Our Ref: 152-2025

Re: Submission on Notice of Direct Planning Application to An Coimisiún Pleanála in respect of a Strategic Infrastructure Development in County Galway – Cashla Peaker Plant, Rathmorrissey and Pollnagroagh, Co. Galway.

Please see comments from regional engineer below in relation to Strategic Infrastructure Development in County Galway – Cashla Peaker Plant, Rathmorrissey and Pollnagroagh, Co. Galway.

Figure 2-2:
Grid Connection Route

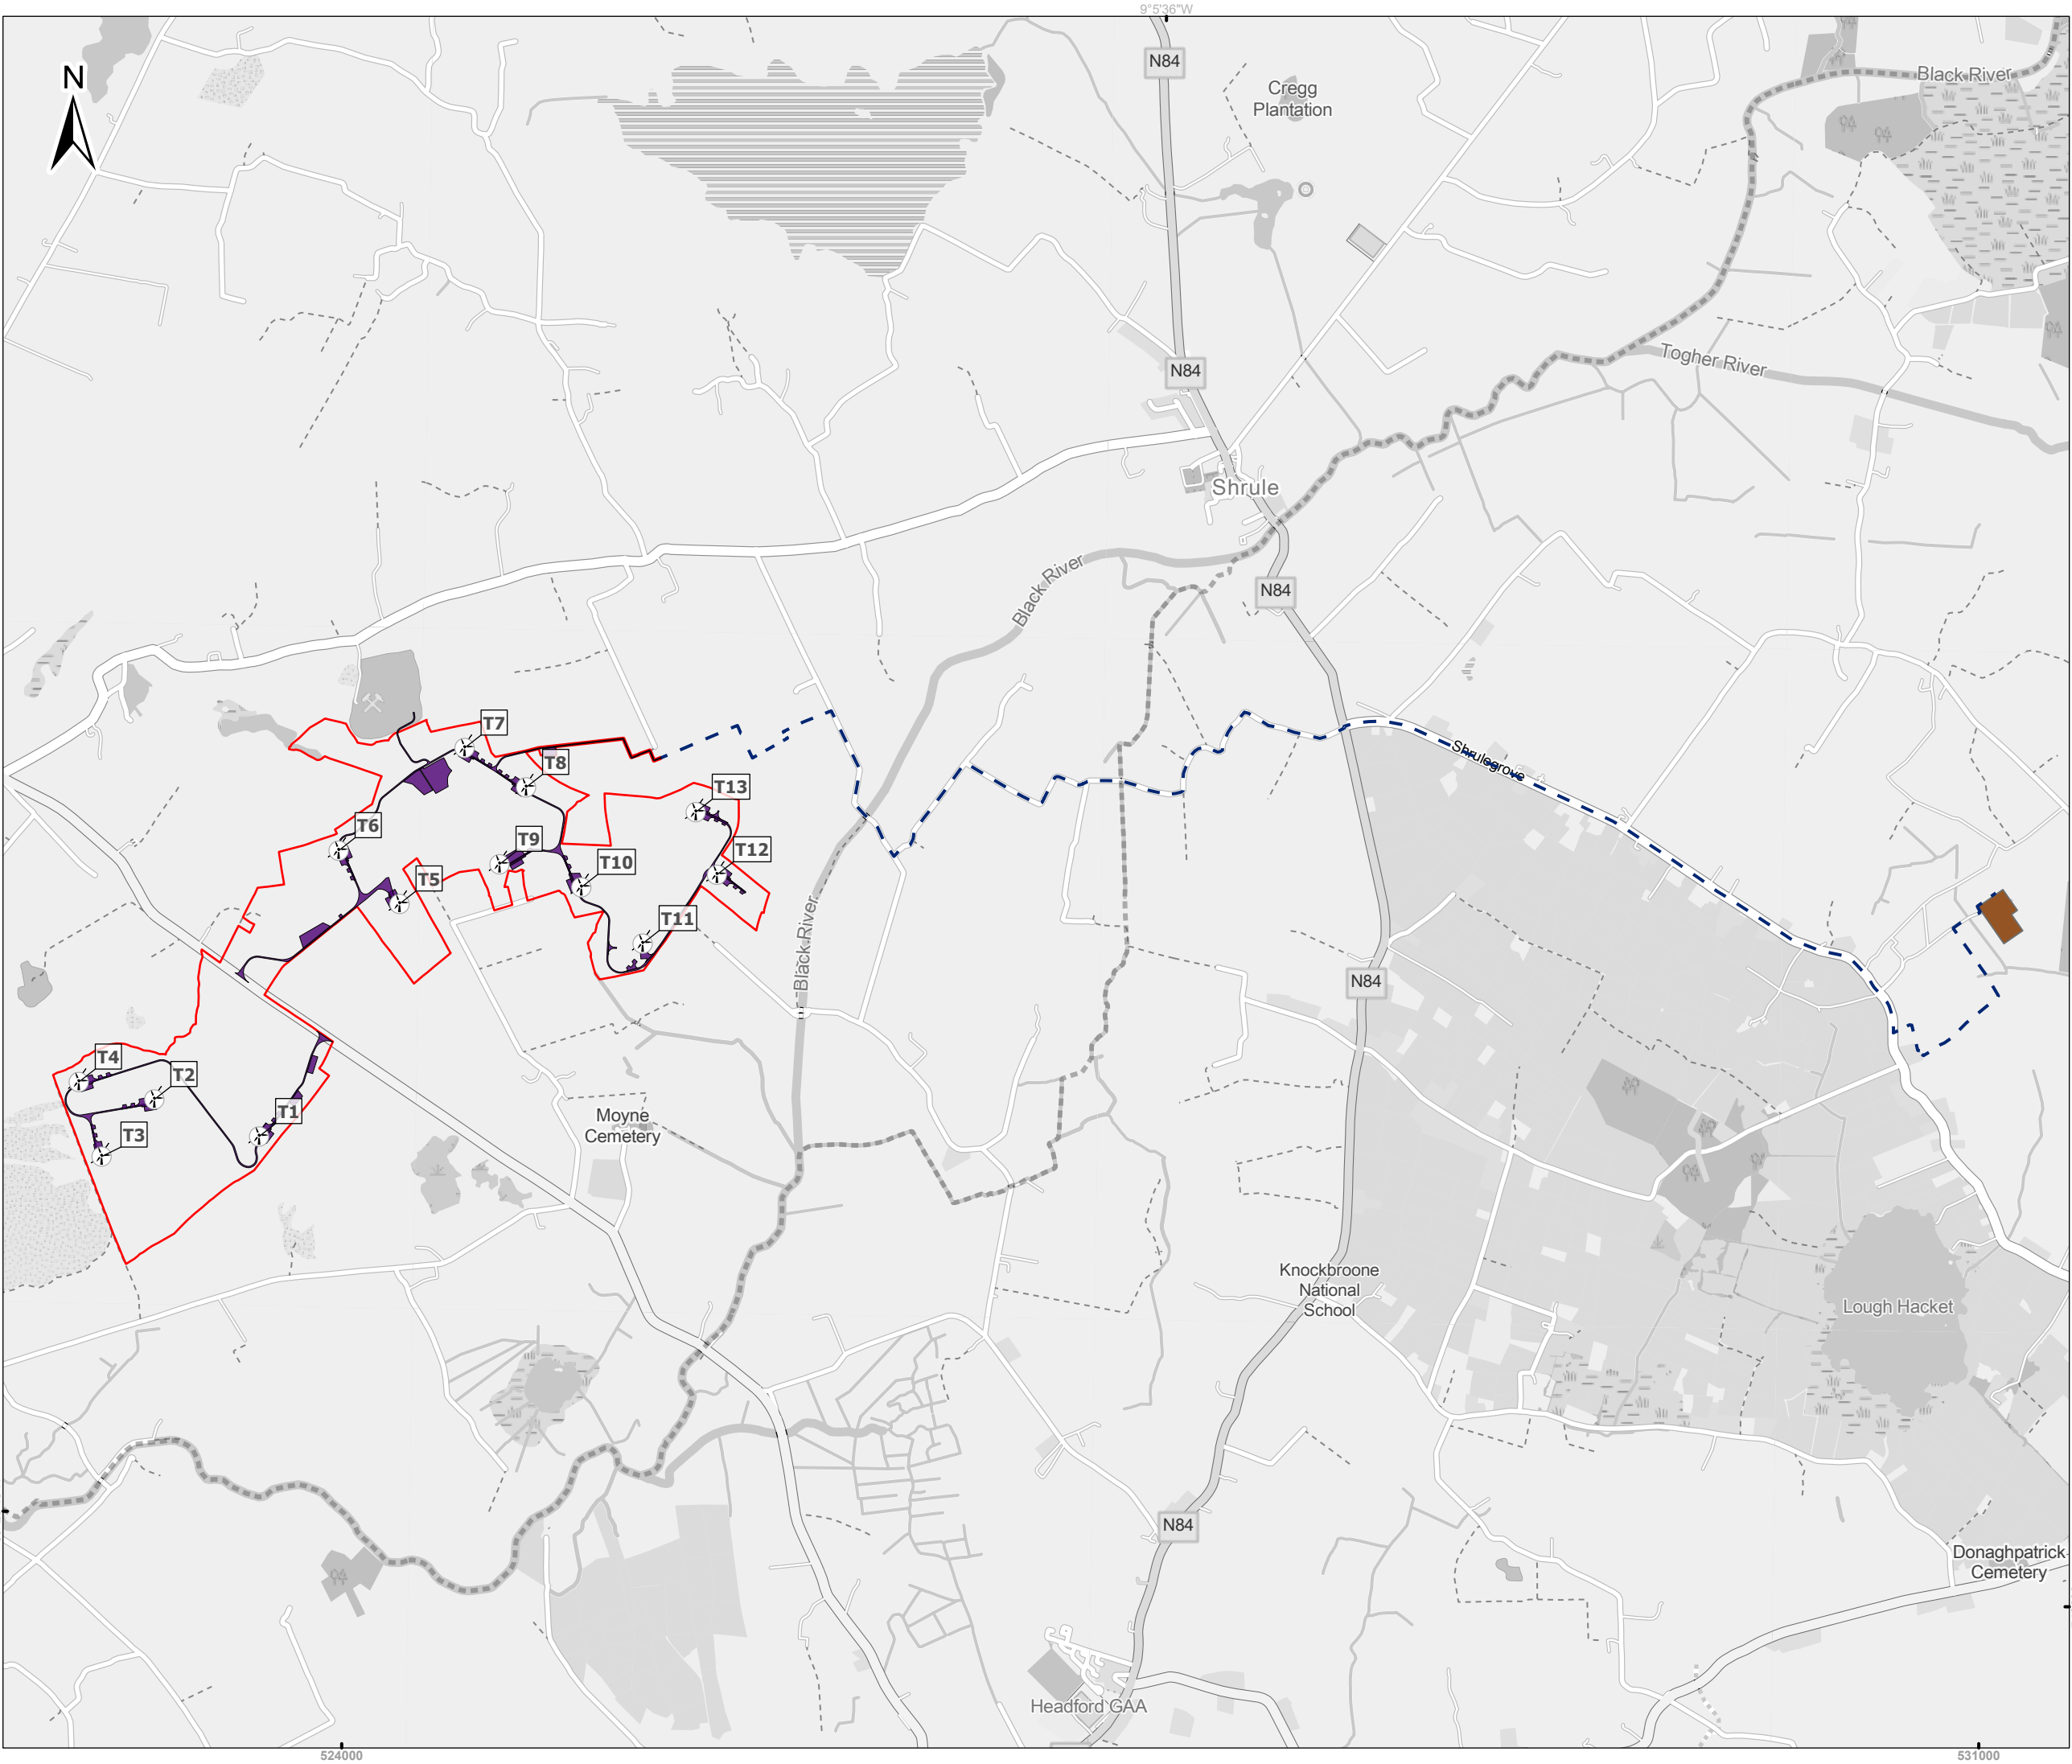
With regard to any proposed Grid Connection Route which may cross several water courses. If the cable and ducting are to be buried in the road, as they cross bridges over the water courses, and there is no interference with the opening in the bridge spanning the watercourse, then there is no issue. On the other hand, if it is proposed to pass the cable in its ducting through the opening of any bridge or culvert, this would be considered to be a modification of a bridge and it would require the consent of the Commissioners under Section 50 as mentioned above. Similarly, if it is proposed to carry the cable in its ducting across watercourses on new support structures spanning the watercourses, these should be treated as if they are bridges, and the consent of the commissioners under Section 50 should be obtained. If the cable and ducting is to be buried under the natural bed of the watercourses being crossed, Section 50 would not apply, and we would recommend that the duct be buried a sufficient distance below the natural bed to allow for erosion and mobility of the stream bed.
